From: Simon Davis
Sent: 01 November 2021 11:33
To: Daniel Medrow [REDACTED]
Subject: RE: Vistry Yapton - Y/72/21/DOC - Y/19/16/OUT

APPENDIX D – Extent of Ditch Regrading 18-070/232A

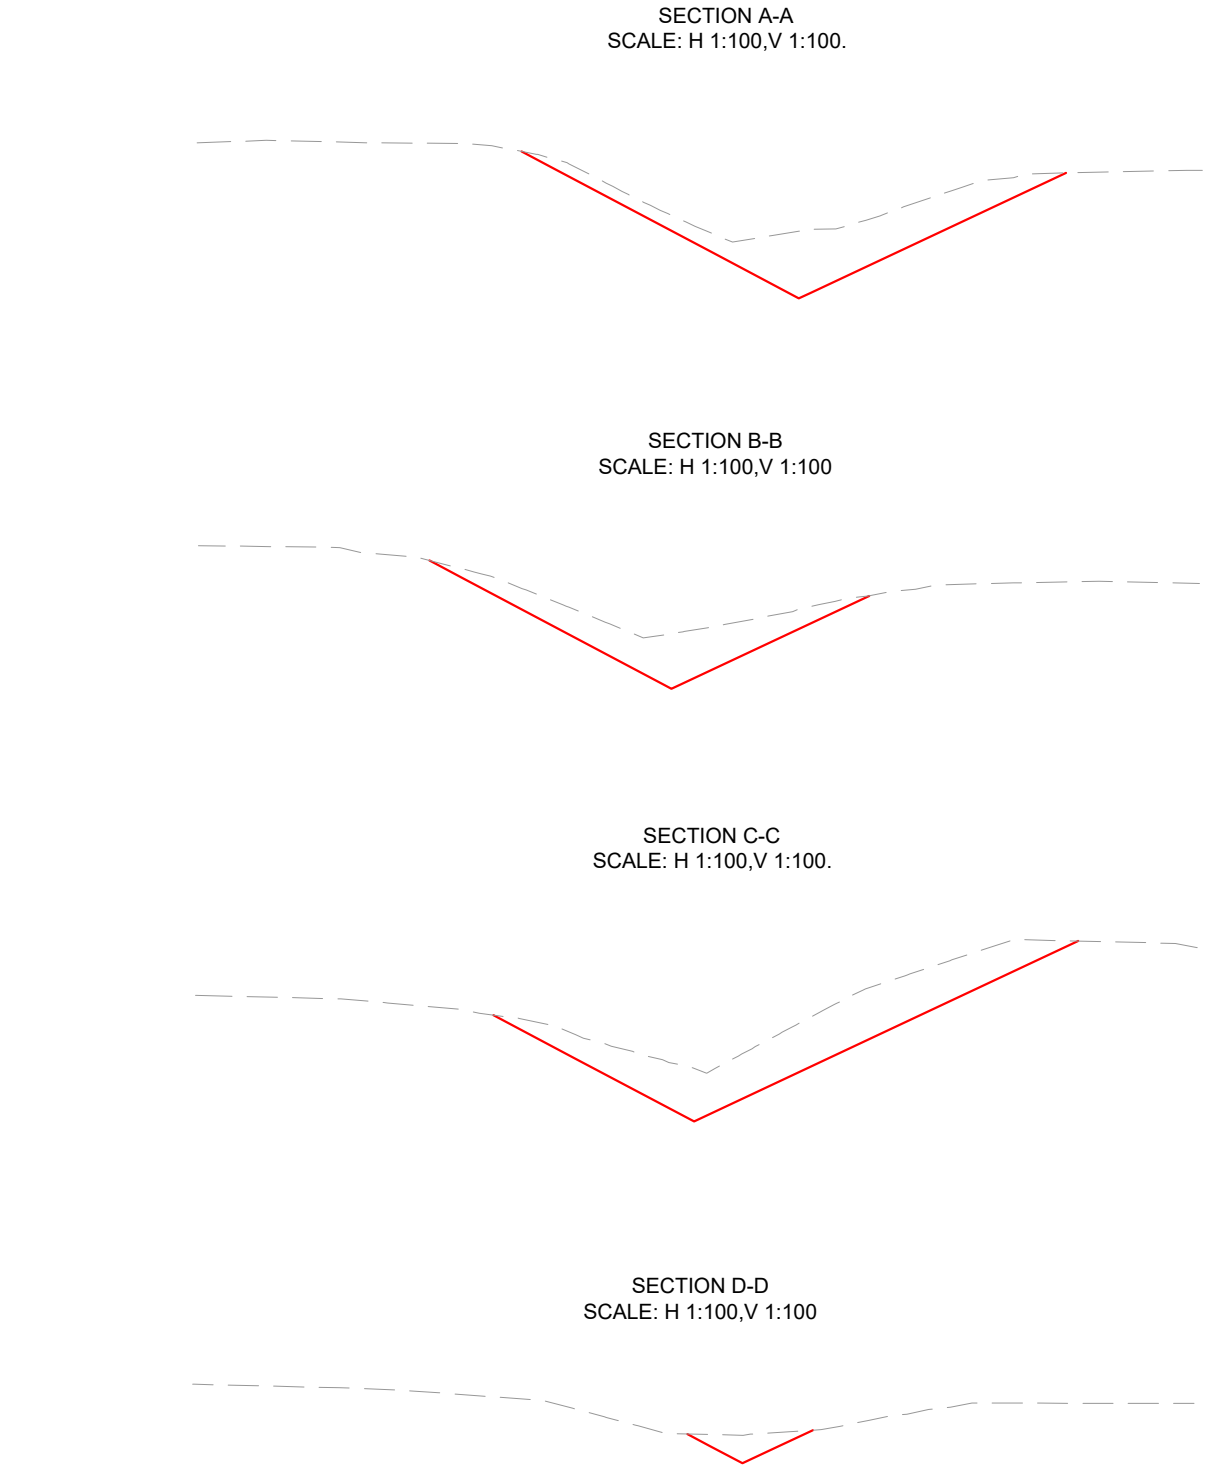
Sorry not yet. He (Karl Roberts) had asked our Engineer (Roger Spencer) to comment further but then Karl was away last week (and again this week). As a heads up, Roger has suggested that we could get you to uncover what we believe to be the start of a culverted system going into the airfield system to the south.

Currently, the topo survey doesn't really demonstrate a) the existence of the culvert and b) the level at which that might sit. It may give a more advantageous gradient but it may just be delaying the inevitable. Furthermore, if it were to make it more viable, the widening/deepening works would still affect 7 trees (3 large, 4 small) in the stretch of ditch between the Vistry and the Crayfern sites.

Just to let you know that I have now had comments from Roger Spencer which suggest that the ditch deepening/widening will not be achievable as third party owners are unlikely to agree to it. I have written to our Director today to seek his view on whether we can discharge the condition.
